Harnett County

Permit Number: BRES2305-0035

Description: 55x58 4bed/ 3baths crawl

| SENT DATE | RETURNED DATE | DUE DATE | TYPE | CONTACT | STATUS | REMARKS |
|--|---------------|-----------|----------------------|--------------|--------------|----------------------|
| 7/1/2025 | 7/10/2025 | 7/10/2025 | RESIDENTIAL BUILDING | Brad Sutton | DISAPPROVED | Plans in attachments |

3 FOUNDATION AT GARAGE DOOR DETAIL
1" = 1'-0"

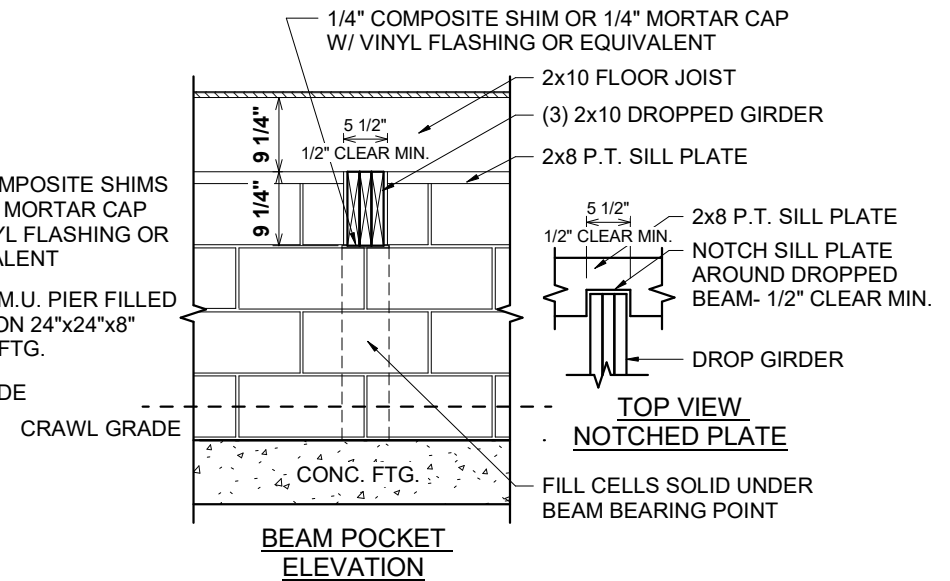
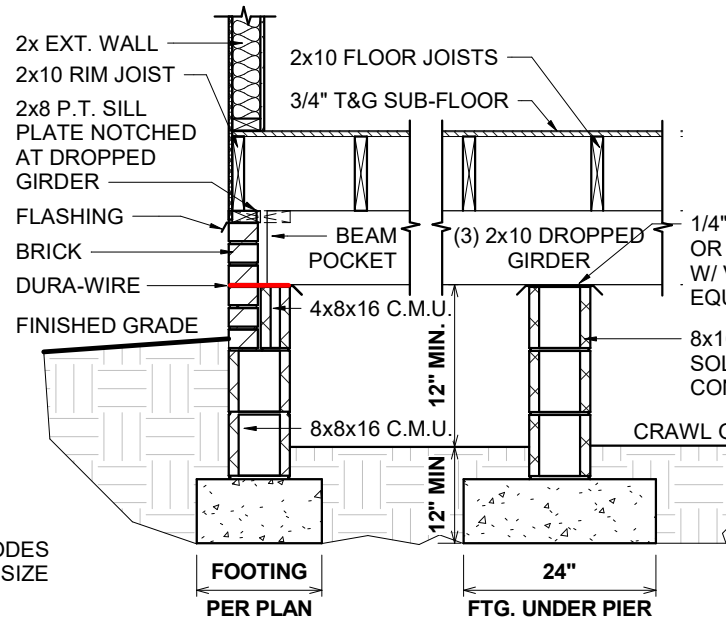
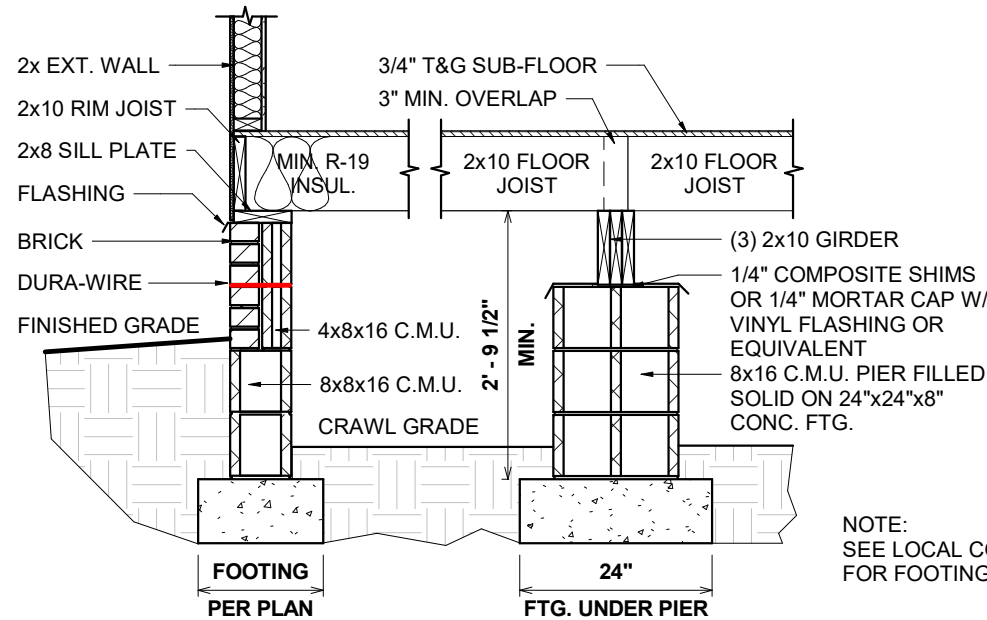
| SENT DATE | RETURNED DATE | DUE DATE | TYPE | CONTACT | STATUS | REMARKS |
|--|---------------|-----------|----------------------|--------------|--------------|----------------------|
| Notes: Customer changed from mobile home to stick built(reason for BRES instead of SFD) and needs septic expanded- Plans in attachment Provide calculation sheet for garage door header (Engineered product) All walls with stud height in excess of 10' must be designed by NC Engineer. | | | | | | |
